From: Nolan, Chris <Chris.Nolan@lancashire.gov.uk>
Sent: 20 October 2017 10:49
To: Stephen Kilmartin; planning
Cc: LHS Customer Service
Subject: D3.2017.0724 - Units 4 and 5 Lincoln Park Industrial Site Lincoln Way Clitheroe

Planning Application No: 3/2017/0724
Grid Ref: 375229 442262
Proposal: Extension to body shop.
Location: Units 4 and 5 Lincoln Park Industrial Site Lincoln Way Clitheroe BB7 1QD

**PROPOSED SITE PLAN**

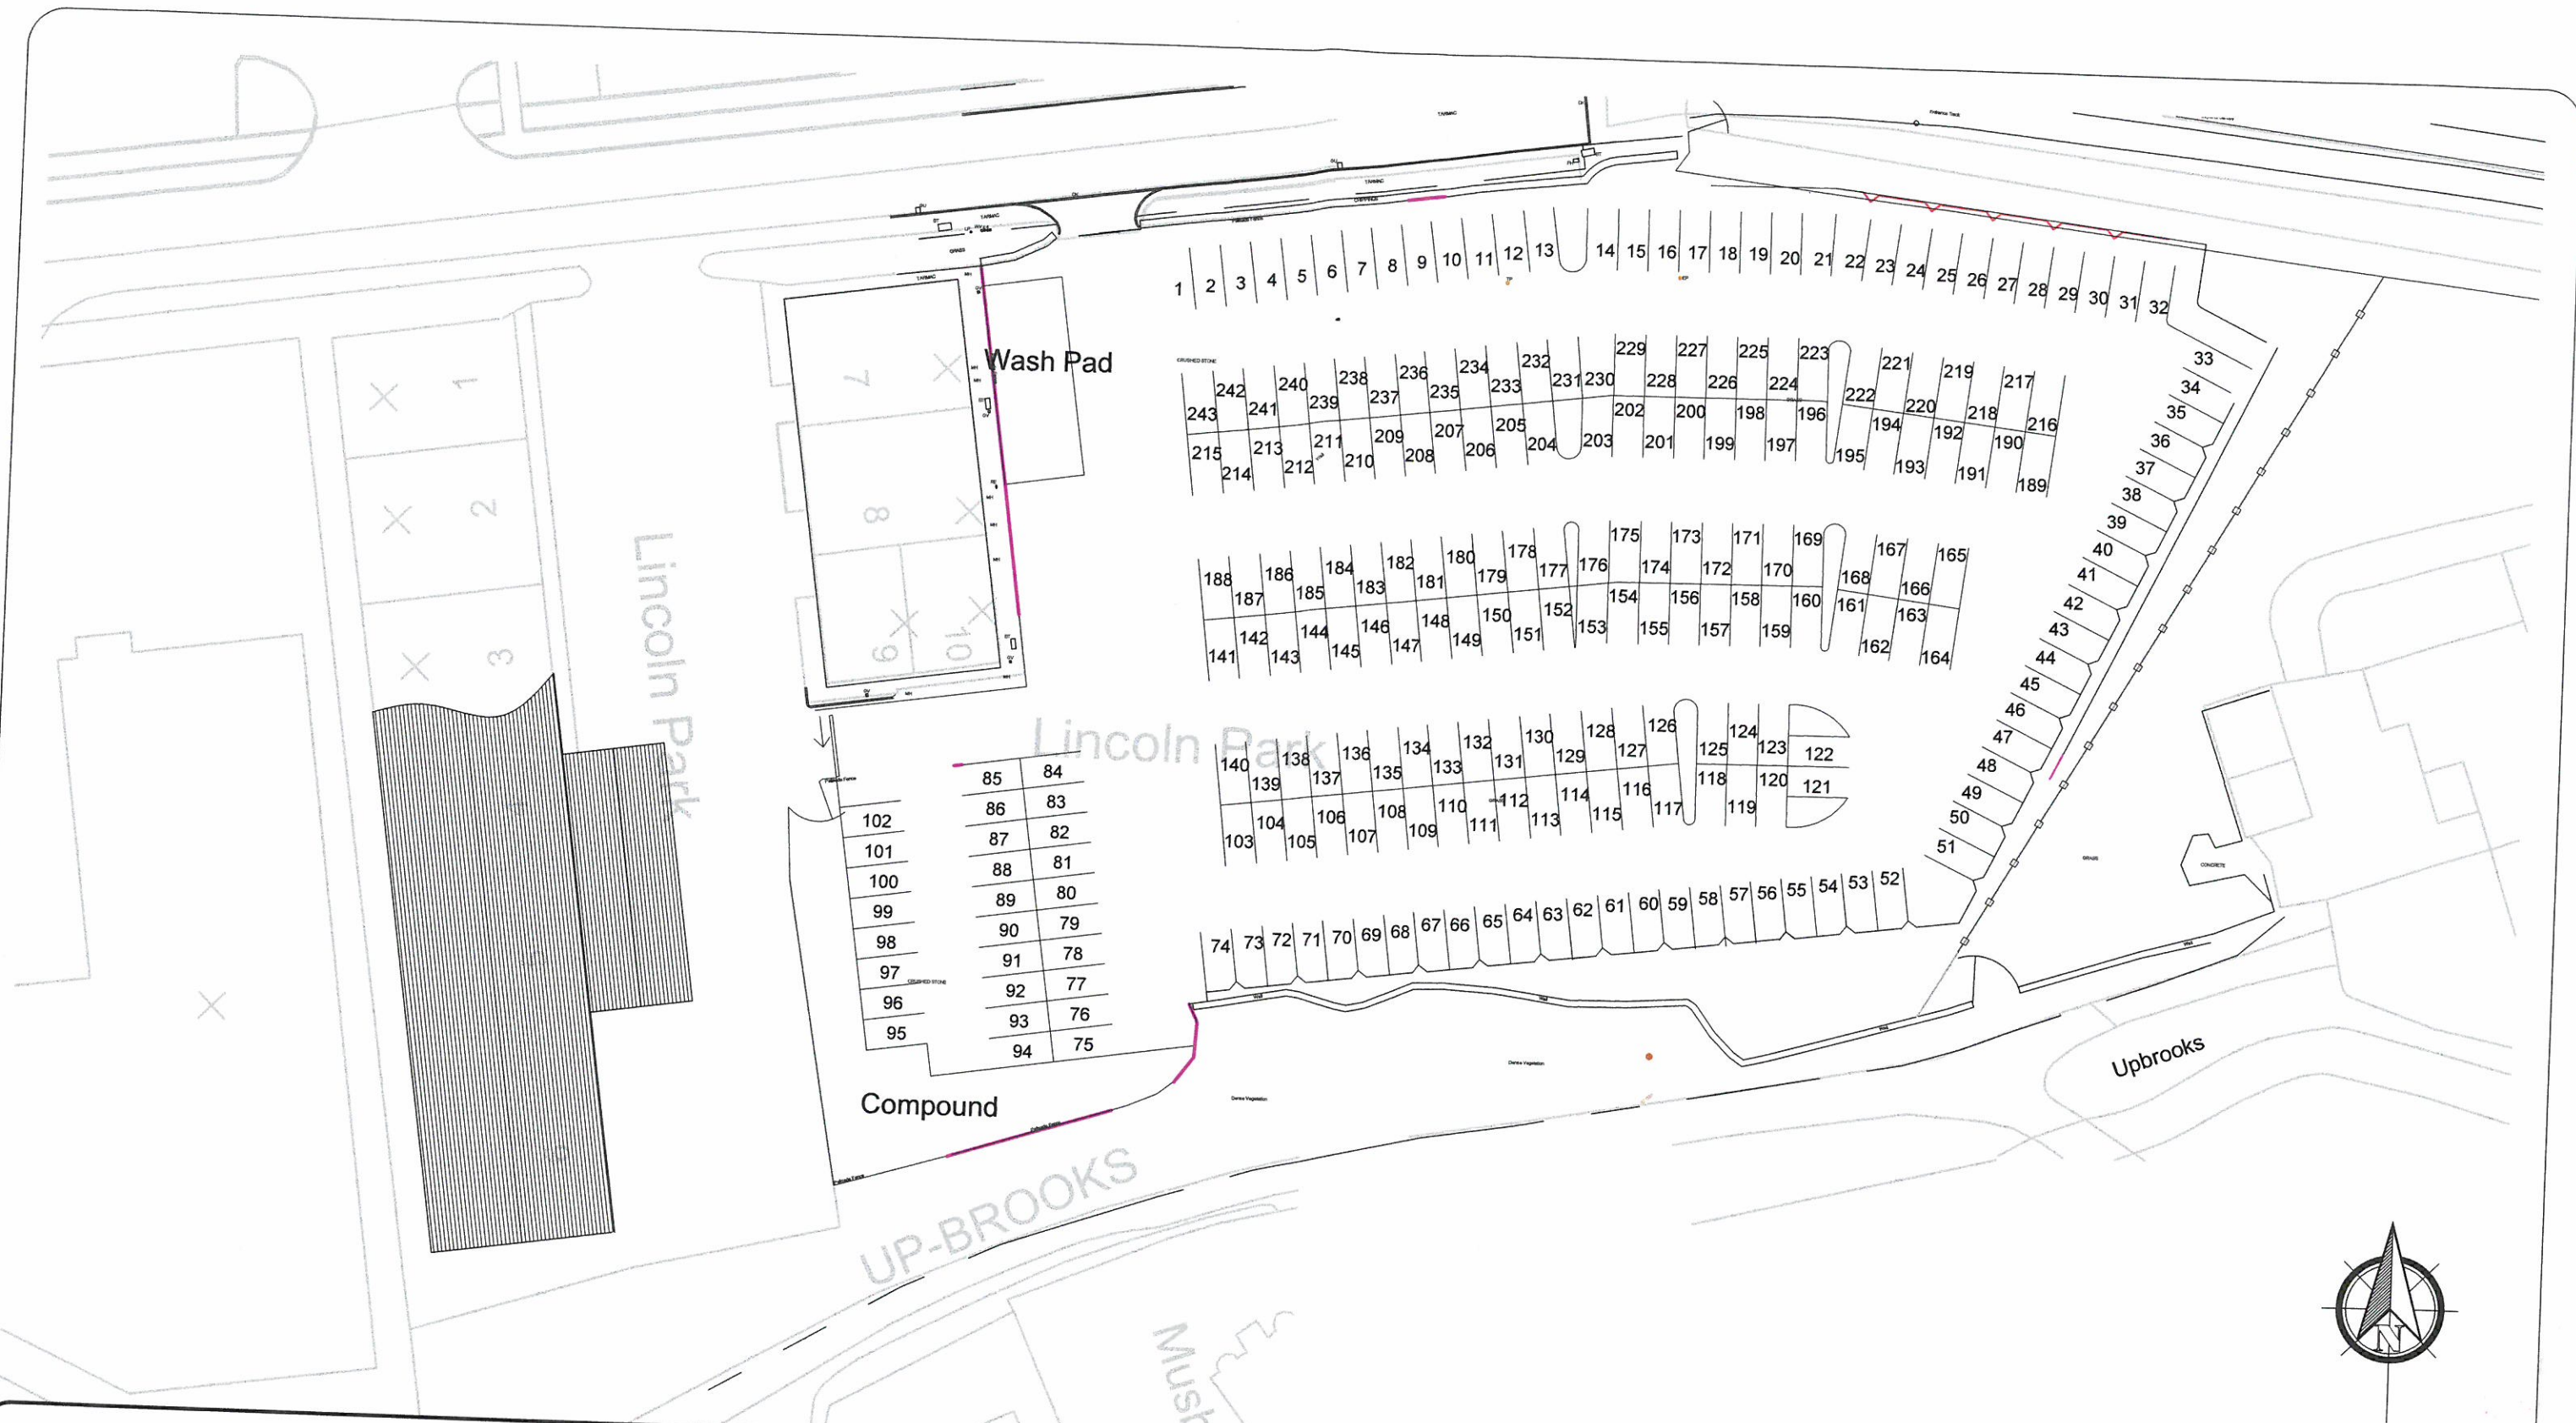
With regard to the above planning application. The applicant occupies a large part of the industrial estate but this application seems to be isolated to units 4 & 5 Lincoln Park Industrial estate. The application form indicates that these two units would be extended from 230m² to 380m² removing the parking for these two units. Whereas under the present occupation the extension would have very limited highway impact. Should the industrial units become available for a different tenant then the extension would be over the allotted parking. I feel that as long as units 4 & 5 Lincoln Park remain as standalone designated industrial units then the parking for these units should be retained. I feel that whilst looking at the declaration on the presented application form I would have to object to the development on the grounds that the extension will result in the units not having sufficient parking in line with the present standards.
